COMMENTS: \_\_\_\_\_

*9-30-21*  
*Need Irons*  
*Need House Stake*  
*Need prof. Lines*

LOT T-2R OLD US 421

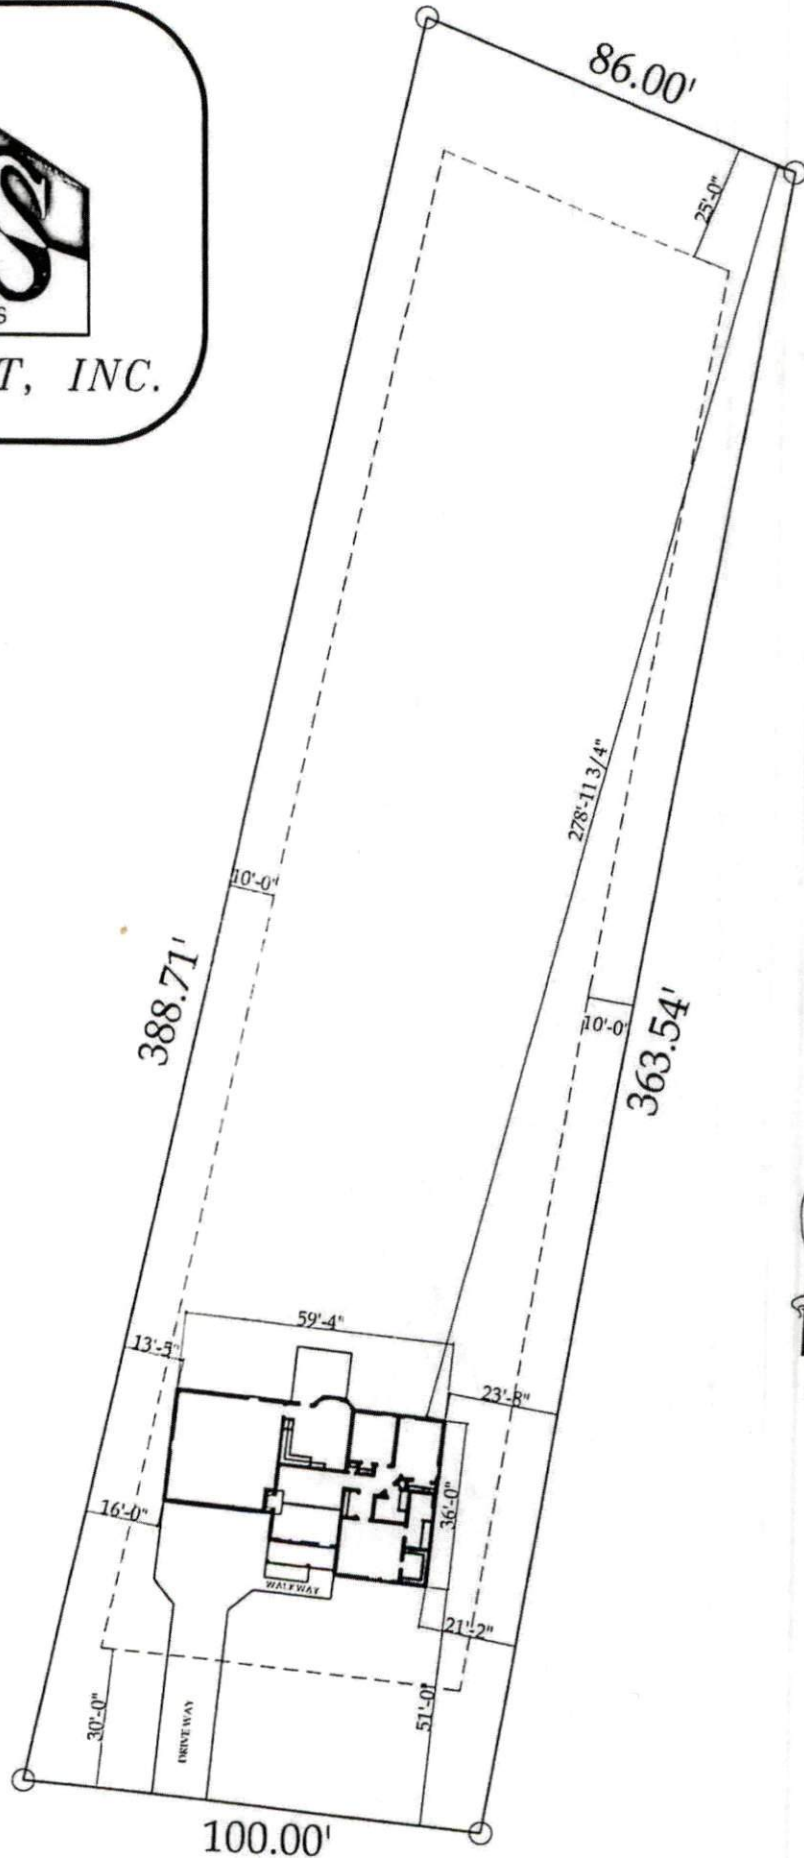
Show profile locations and other site features (dimensions, references or benchmark, and North)
